Ribble Valley Borough Council
Council Offices
Church Walk,
Clitheroe
Lancashire
BB7 2RA

Phone: 0300 123 6780
Email: developeras@lancashire.gov.uk
Your ref: 3/2025/0999
Our ref: 3/2026/0369/HDC/KW
Date: 24 July 2026

Location: 69 King Street Whalley BB7 9SW
Proposal: Proposed part change of use from retail shop to bakery with staff accommodation at first floor (sui generis). Demolition of existing single-storey rear extension and construction of new extension to rear. Installation of retractable frontage canopy, ramp/steps and handrail. Installation of replacement windows, service yard security gates and ancillary external seating.
Grid Ref: 373309 436239

Lancashire County Council acting as the Local Highway Authority does not consider that the application as submitted fully assesses the highway impact of the proposed development and further information is required as set out in this response.

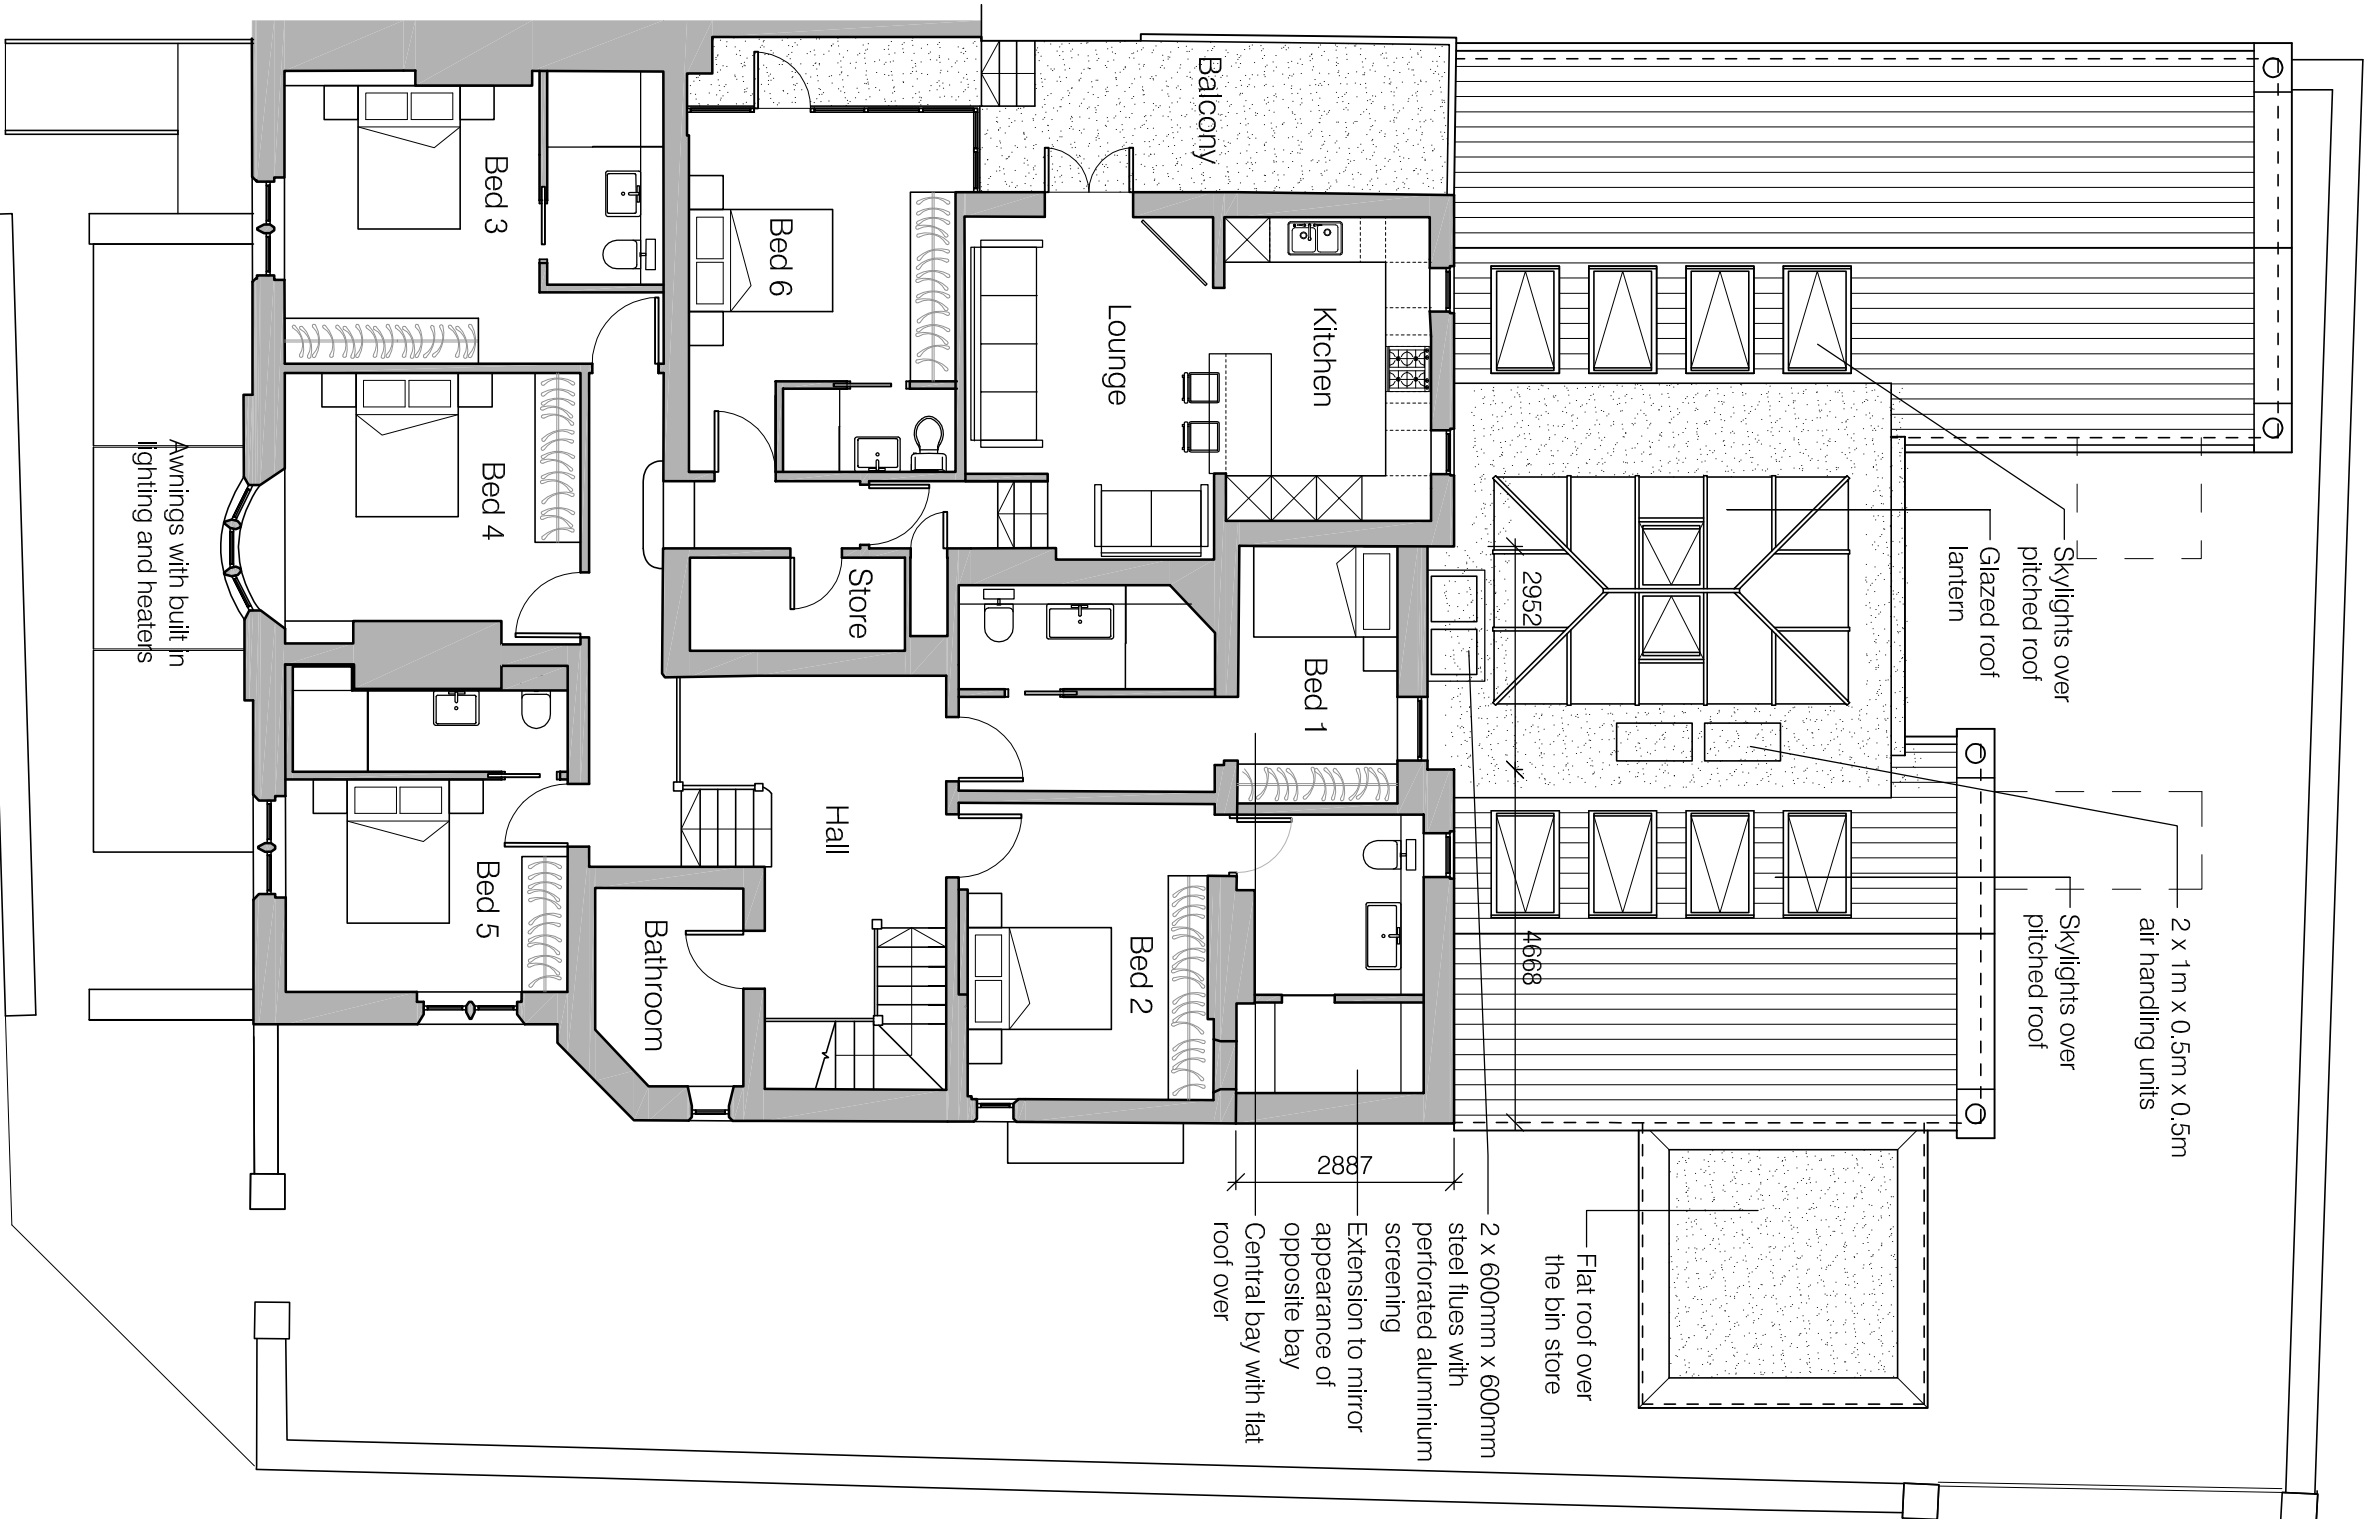
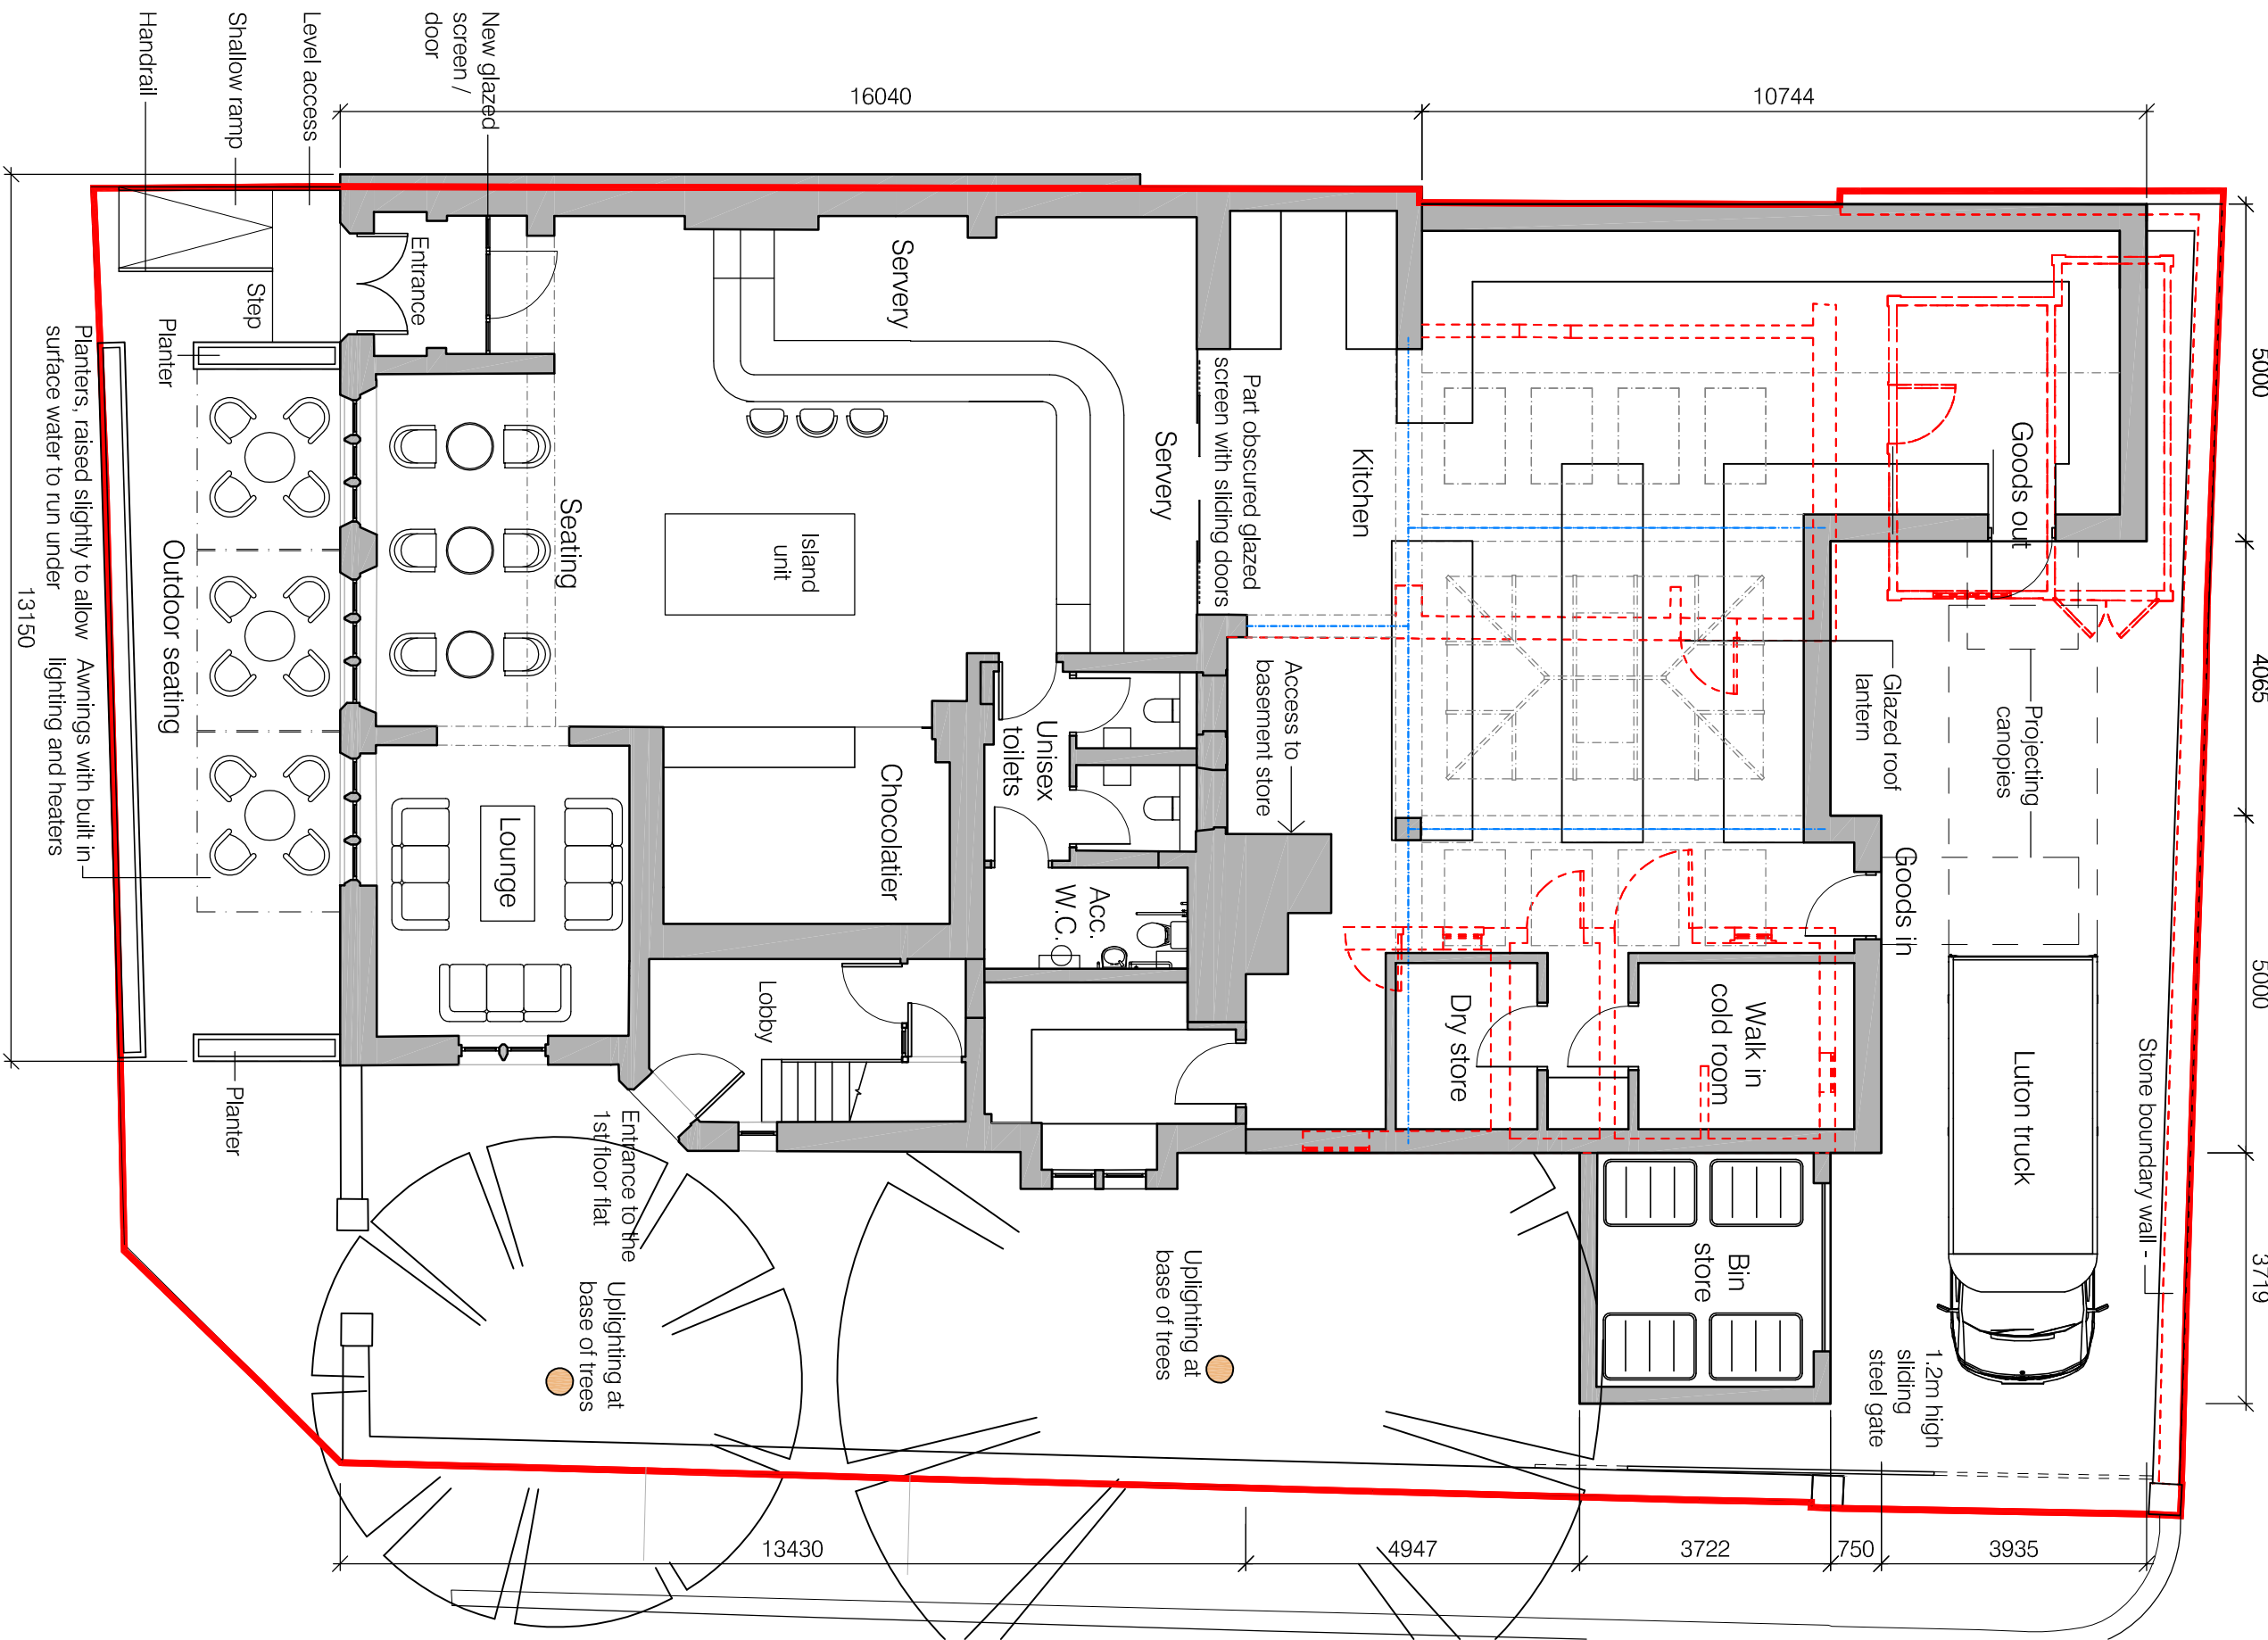
It is understood that the applicant intends to retain the existing vehicle access to provide access to a service area within the site. A 1.2m sliding gate is proposed; however, this has not been set back from the highway edge and, given its height, may obstruct visibility. Further information is required to assess the frequency of use of the access, which will assist in determining the acceptability of the design.

The LHA also has concerns regarding servicing arrangements for the site. The proposal includes a service yard accessed from George Street. George Street accommodates a mix of commercial activity, residential access and on-street parking demand as such, there is a high volume of pedestrian movement fronting the proposed access to the servicing area. A bakery operation of this nature can reasonably be expected to generate regular deliveries. The current service yard arrangements do not include any turning provisions and as such the LHA expects a level of reversing movements into the site. No Servicing and Delivery Management Plan has been submitted and the LHA would request that further information is provided to consider if these arrangements are acceptable in terms of highway safety. Information should be provided detailing:

- If deliveries and servicing will be made via a third party or are operated and controlled by Northcote/the applicant.
- Delivery frequencies.
- Vehicle sizes.
- Delivery hours.
